## **Thanet Extension Offshore Wind Farm**

### Appendix 5 to Deadline 6 Submission: Statement of Common Ground – Estuary Services Limited

Revision C

Run 5

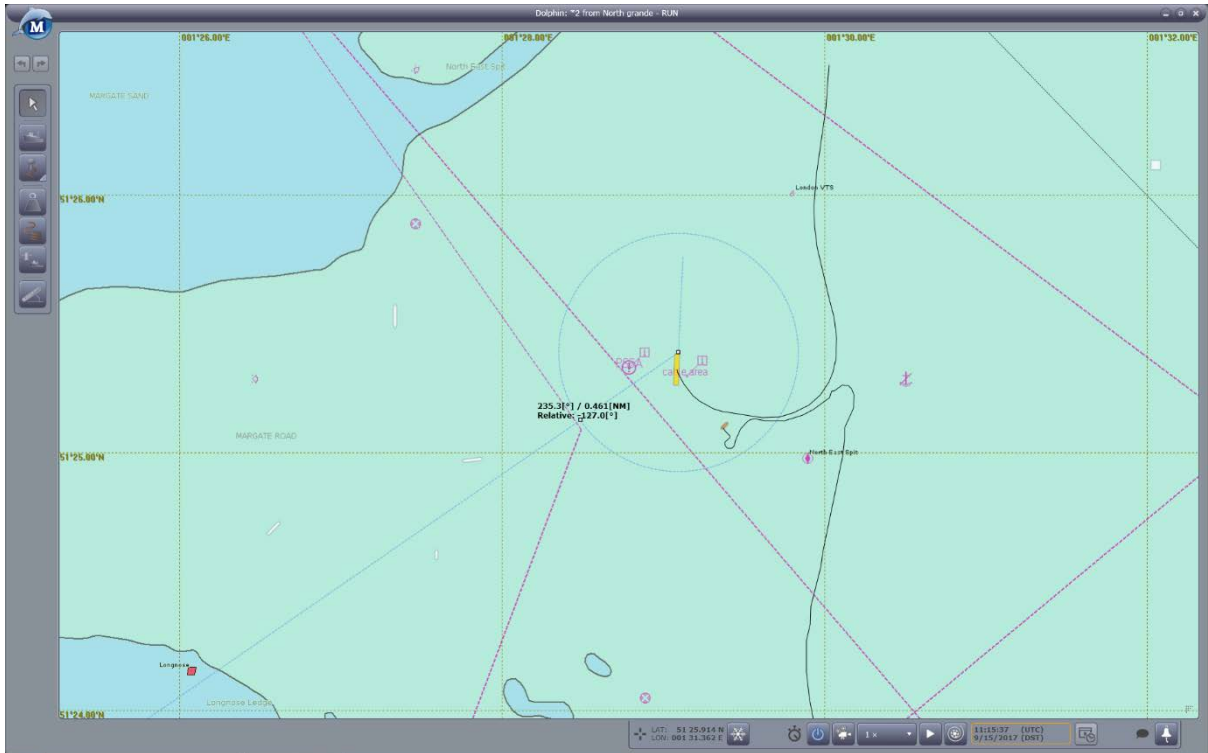
<p>Accompanying documentation</p>	<p>The bridge simulation exercise (Application Ref 6.4.10.2) accurately reflects the study undertaken with Port of London Authority and pilotage providers.</p>	<p>It is agreed that the study reflects the events that took place during the simulator exercise.</p>	<p>Agreed.</p>
<p>Accompanying</p>	<p>The bridge simulation exercise</p>	<p>ESL does not agree that the simulation exercise</p>	<p>Not agreed.</p>

<p><b>documentation</b></p>	<p>(Application Ref 6.4.10.2) accurately reflects the effects on pilotage associated with the original Red Line Boundary.</p> <p>The Applicant understands that ESL considers the weight afforded to the pilot simulation in the NRA to too great, however in accordance with Deadline 3 submissions, it does demonstrate feasibility.</p>	<p>accurately reflects the pilotage operation at the North East Spit for reasons previously explained ESL’s Deadline 1 submissions. Due to the limitation of this study ESL considers that the weight it is given in the NRA is disproportionate.</p>	
<p>NRA addendum - approach</p>	<p>The approach to the NRA addendum and the hazard workshop was presented to ESL in advance for comment. The approach taken by the Applicant is appropriate and matches NRA standard practice.</p>	<p>ESL was presented with a guide to the workshop in advance.</p> <p>As reflected in the MCA’s responses to ISH8 action point 10, ESL does not agree that it is standard practice to attempt such a significant NRA amendment under restricted time pressure. Given the level of agreement and understanding that is required for a risk assessment such as this, ESL does not feel the approach has been appropriate.</p>
